RE: Central Coast Council advice, State Significant Development (SSD-9813), 36-48 Donnison Street, Gosford.

I refer to your request for additional information, dated 26 May 2020, in relation to the above mentioned SSD application. We take this opportunity to provide a response to each of the items raised by DPIE, outlined in the table below.

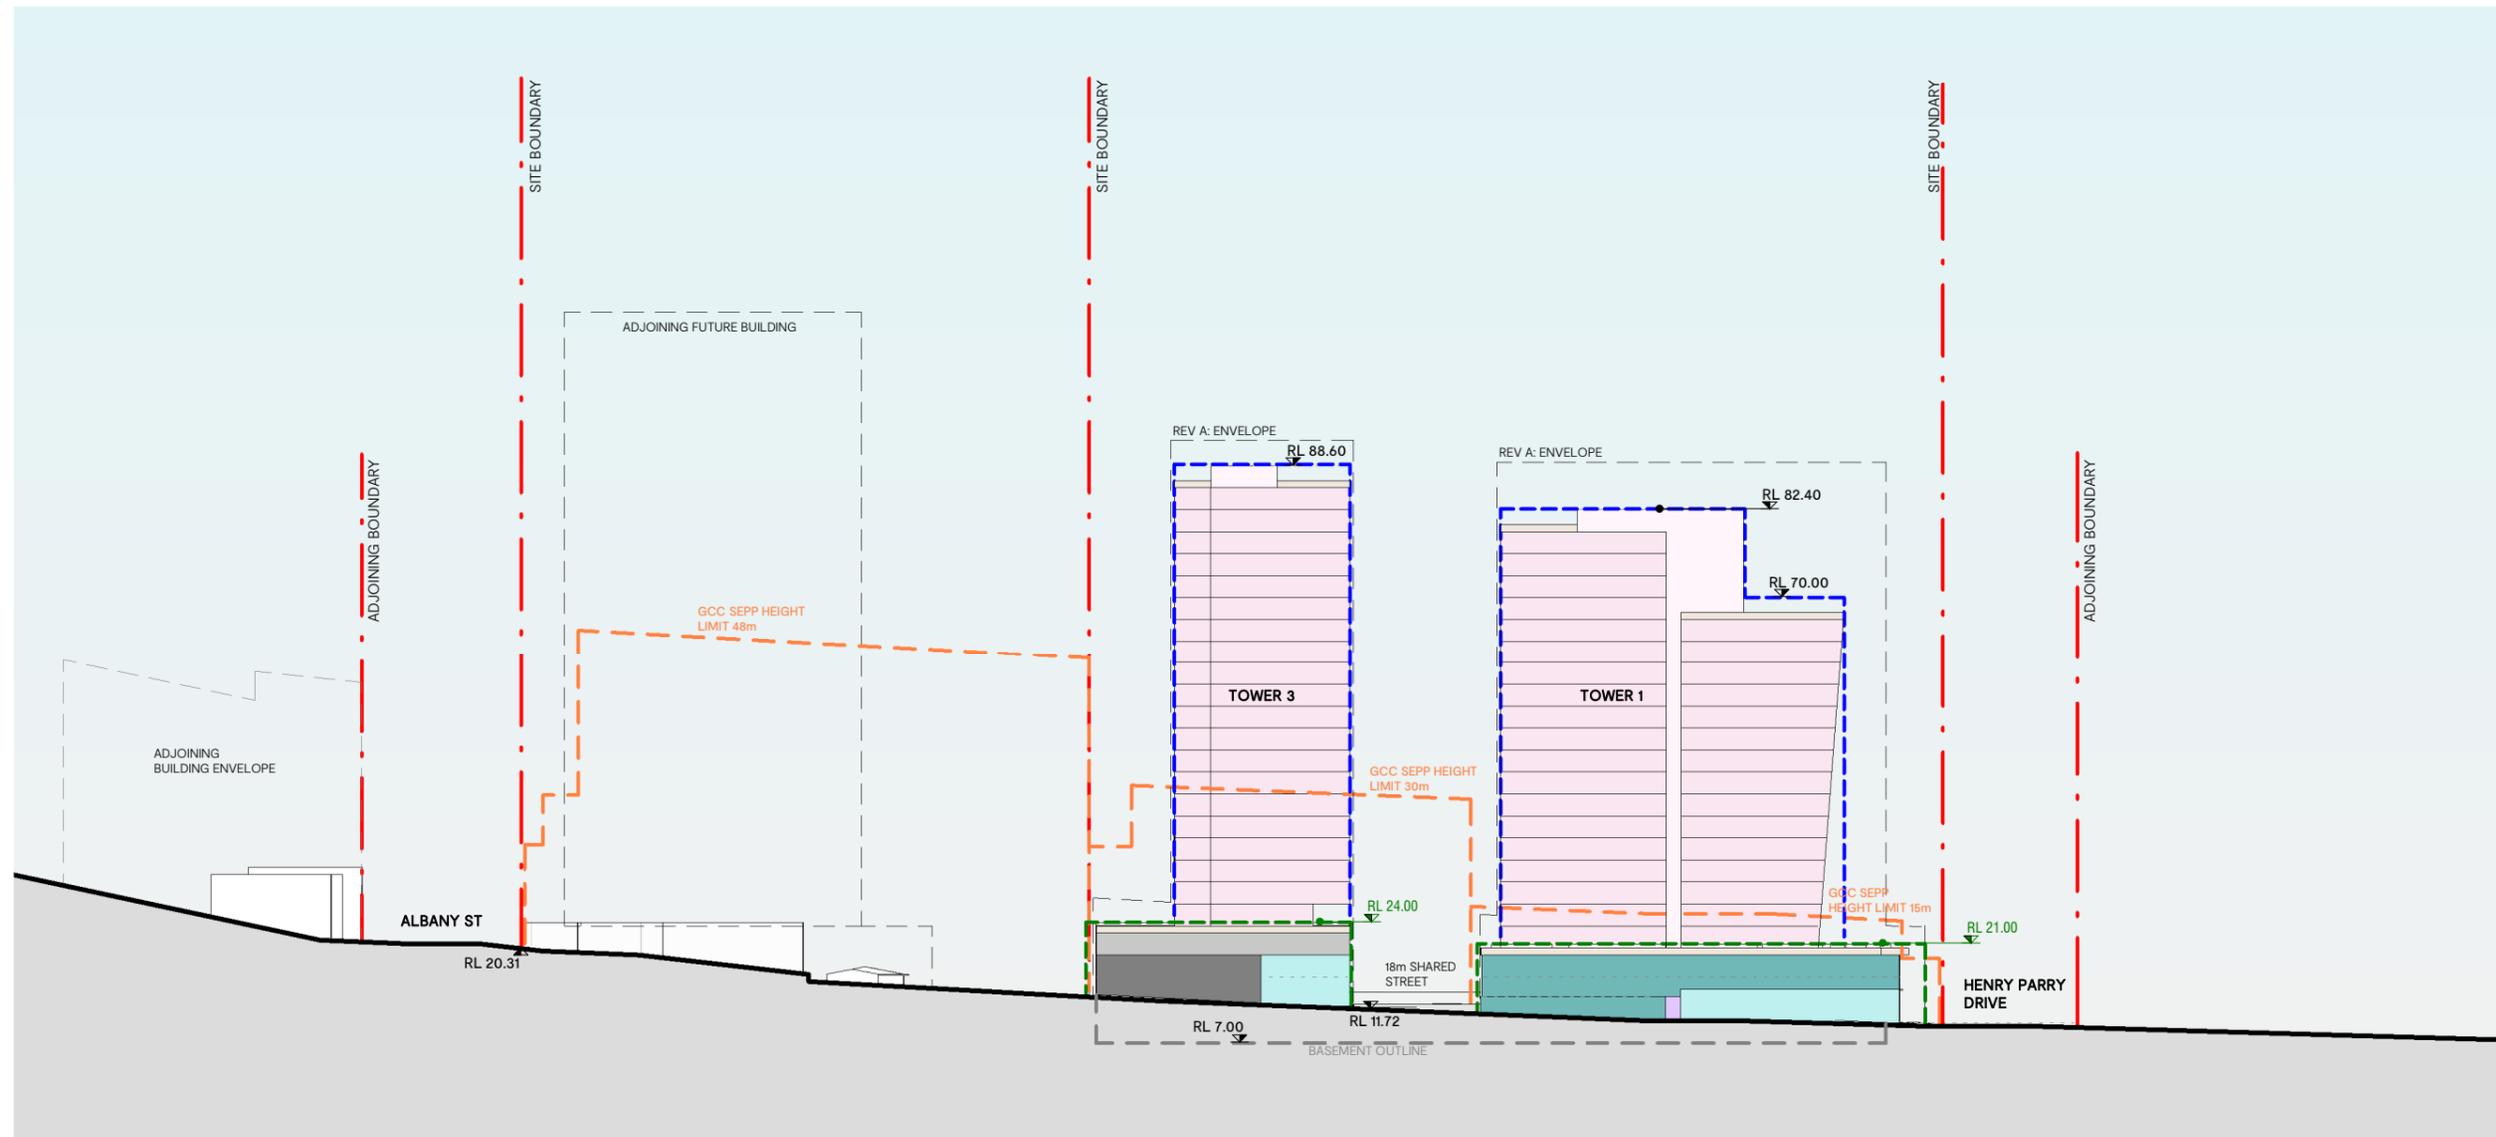
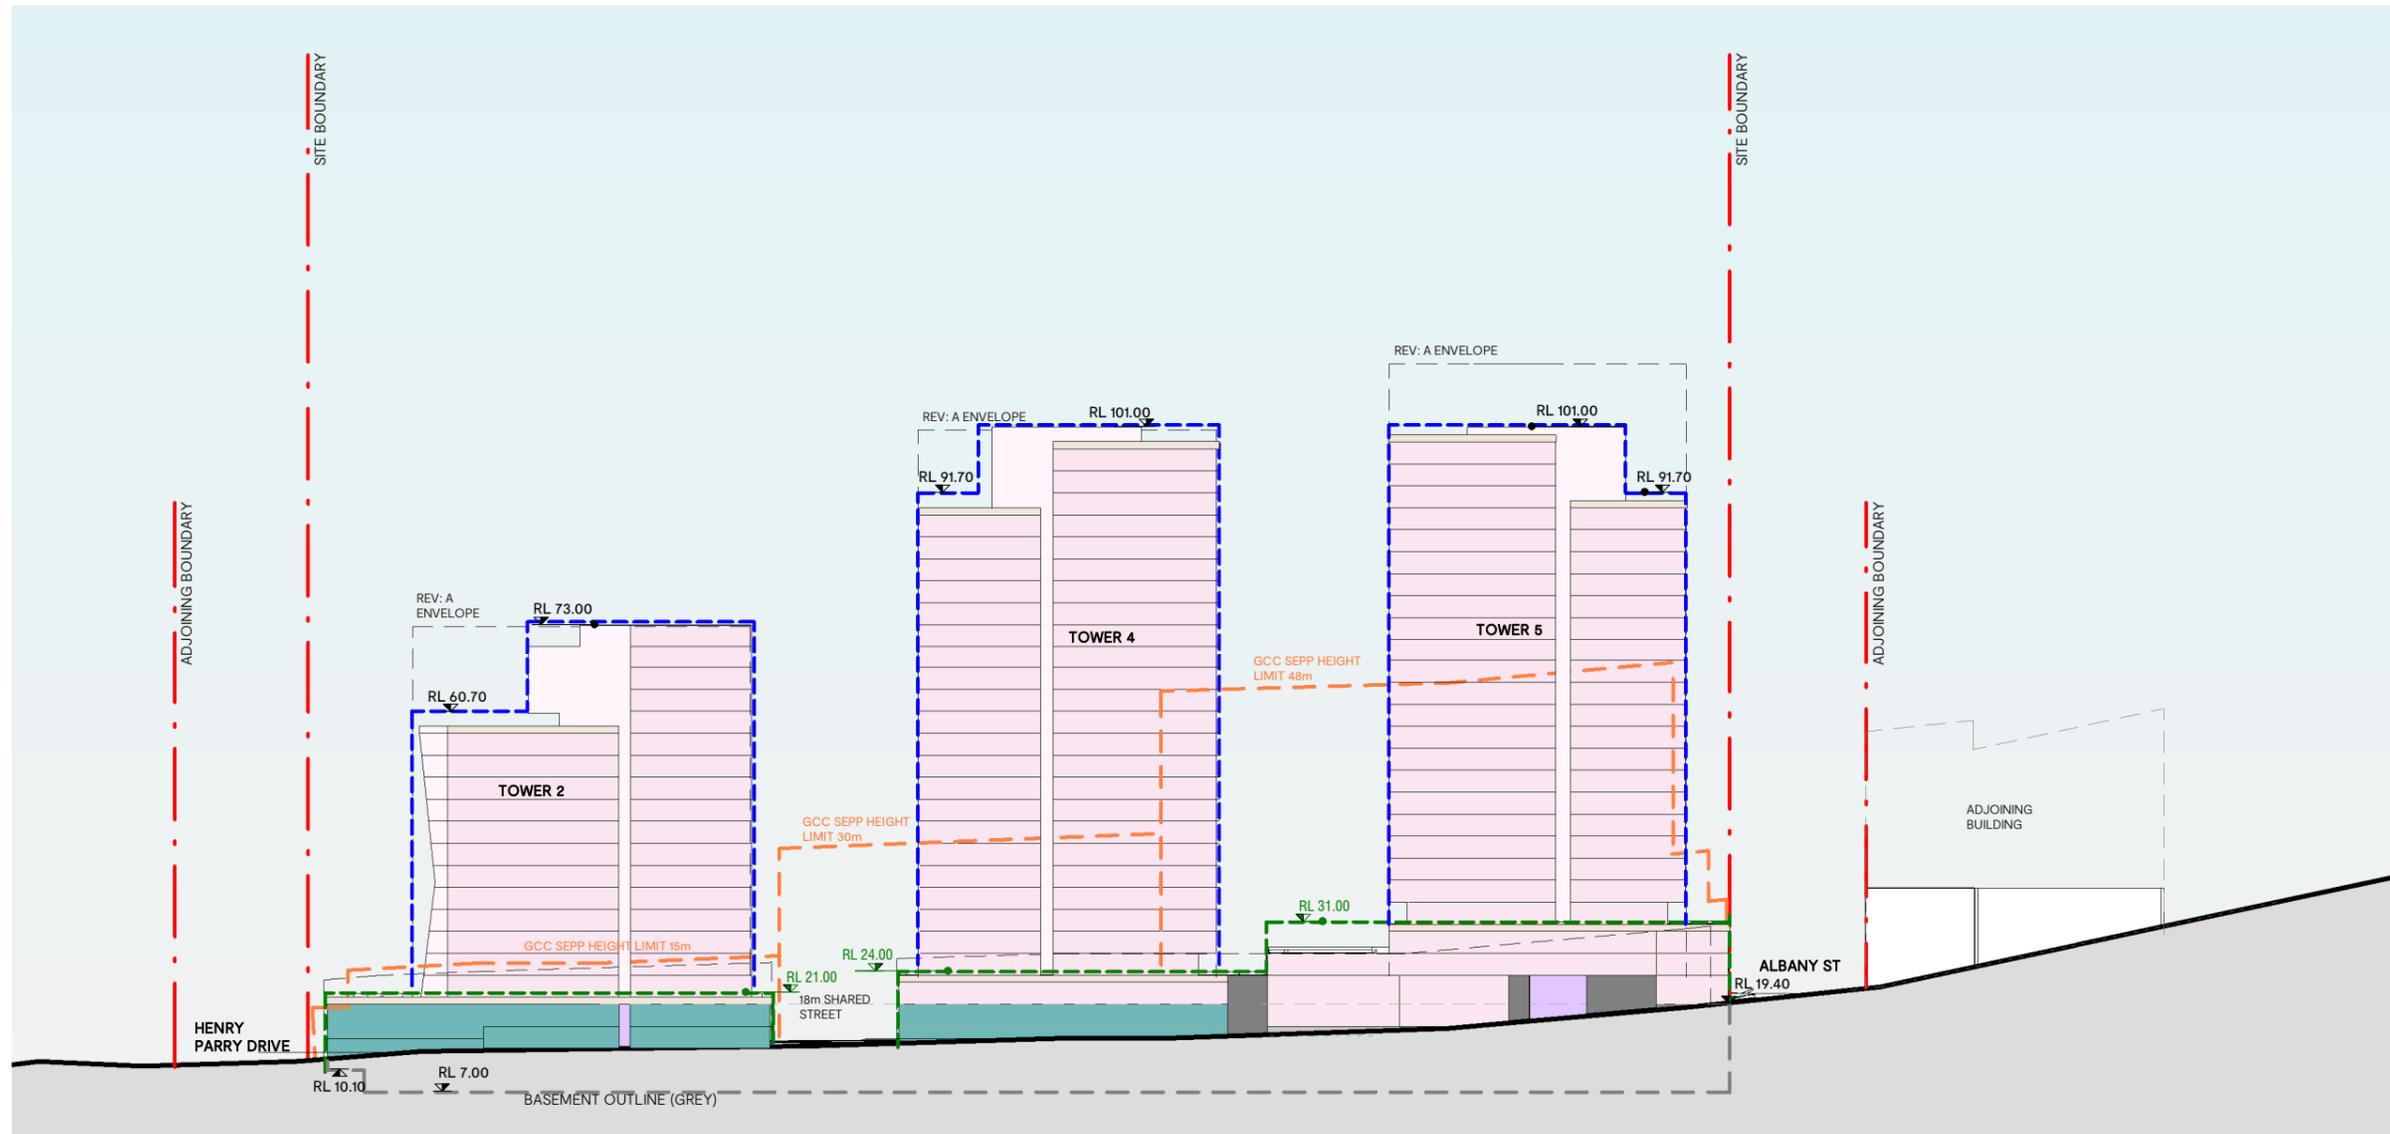
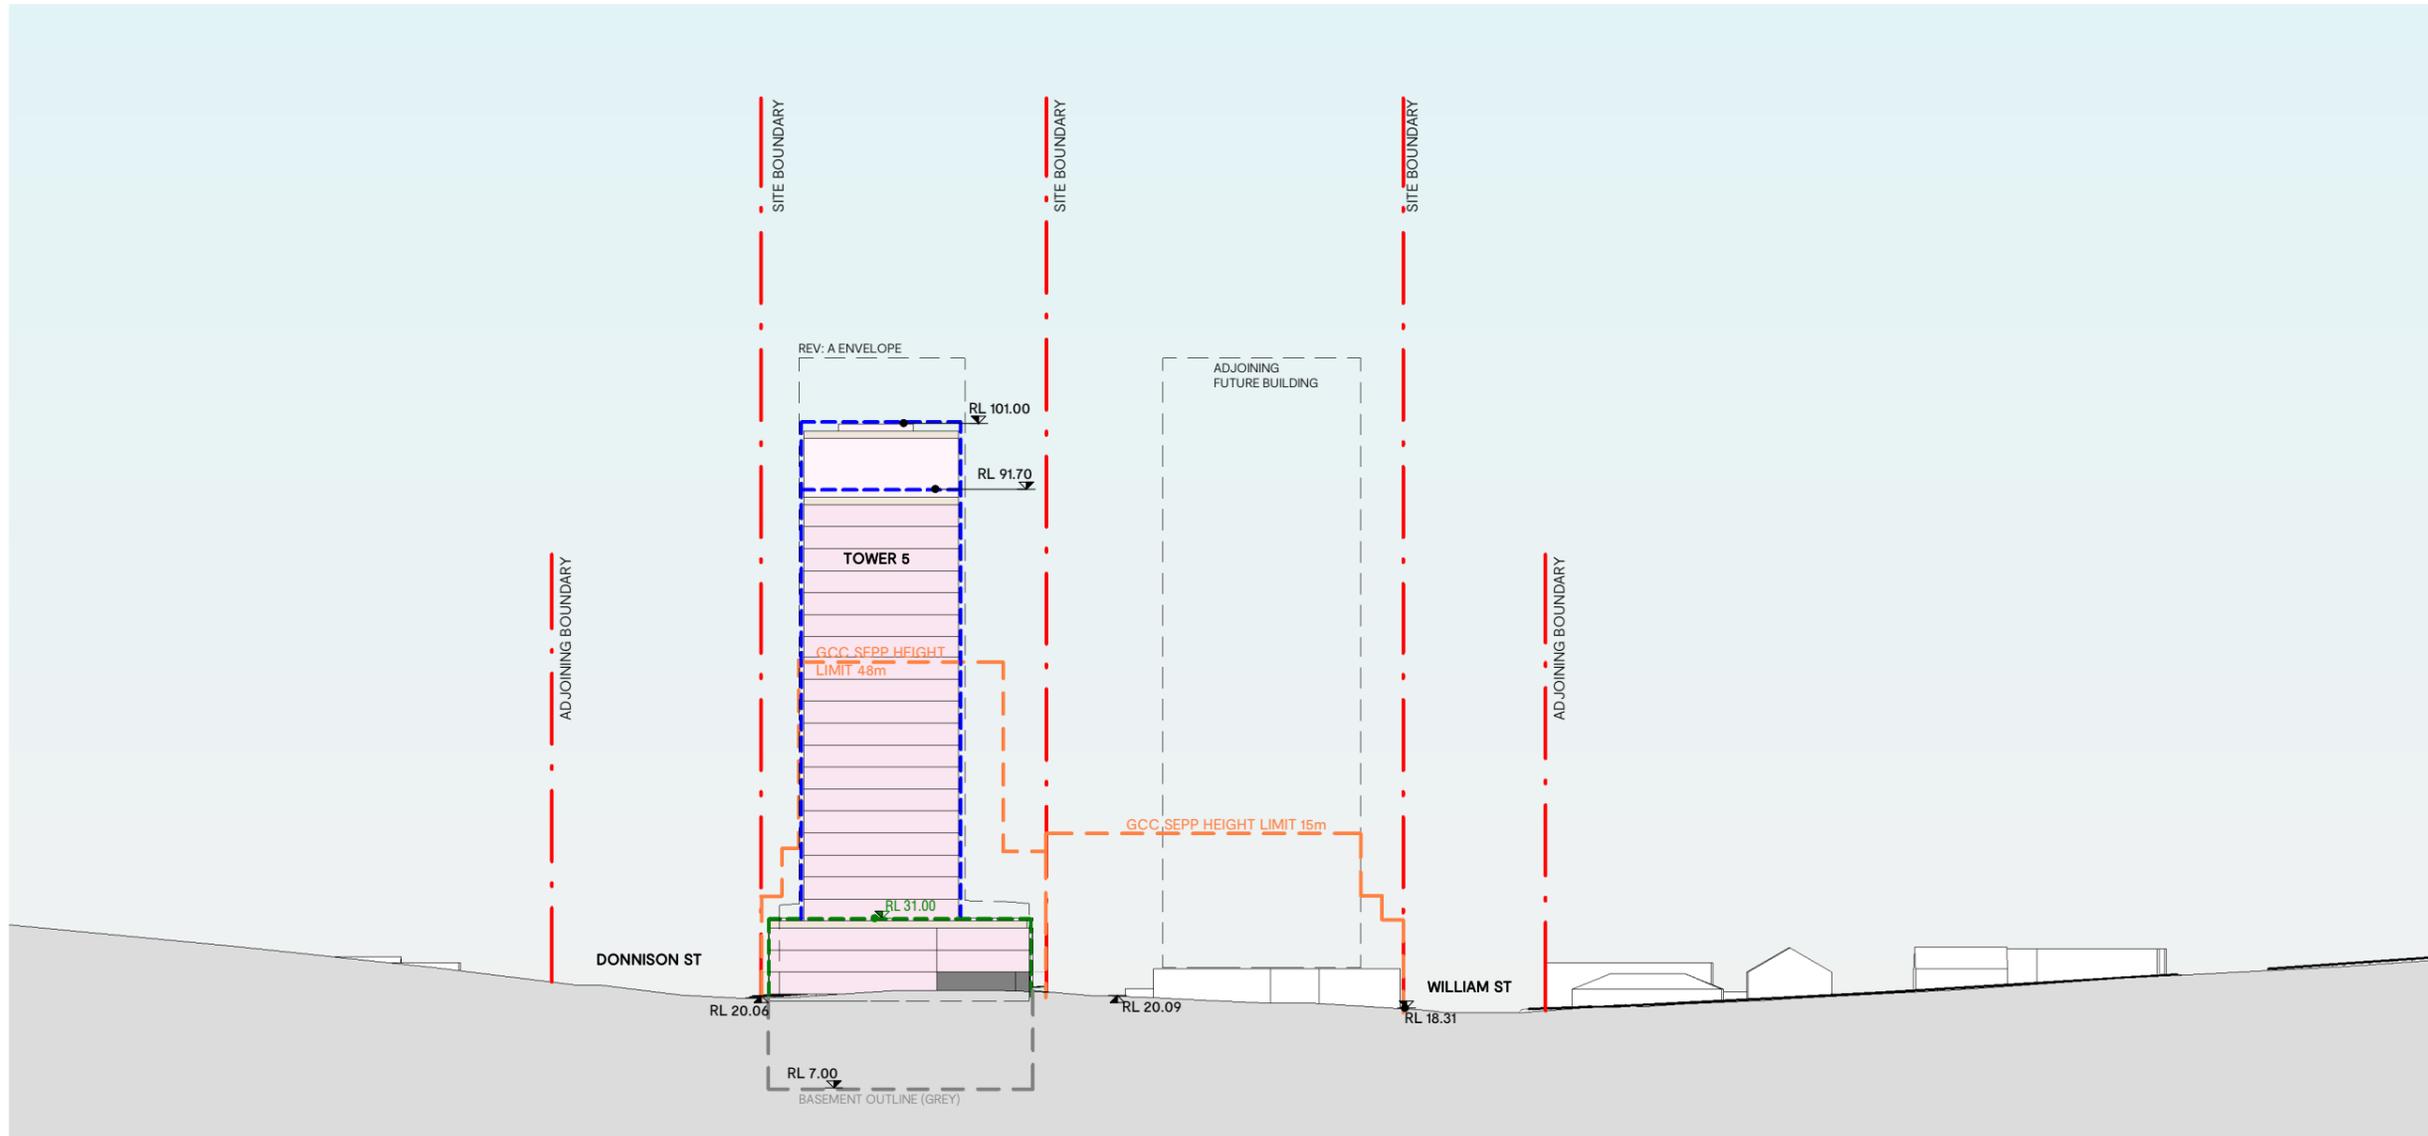
Please update elevations to show basements.	As above.
<p>Please provide an updated version of the block massing images ... to include current RtS envelopes:</p> <ul style="list-style-type: none"> • Page 25 to show the RtS envelopes in context with other approved (108 Mann St and 50-70 Mann St) and potential (imperial Centre) towers. The field of view should be slightly wider to more clearly show the above envelopes. • Page 69 to show the RtS envelopes in context with immediate surroundings. 	These images are currently being updated and will form a part of the updated VIA, which will be submitted to DPIE by 12 June 2020 at the latest.
Update the photomontage provided at page 12 of the VIA to include the massing of the development (in green). Also review the heights of 50-70 Mann Street to ensure they accurately reflect the development consent heights.	The updated VIA will be submitted to DPIE by 12 June 2020 at the latest.
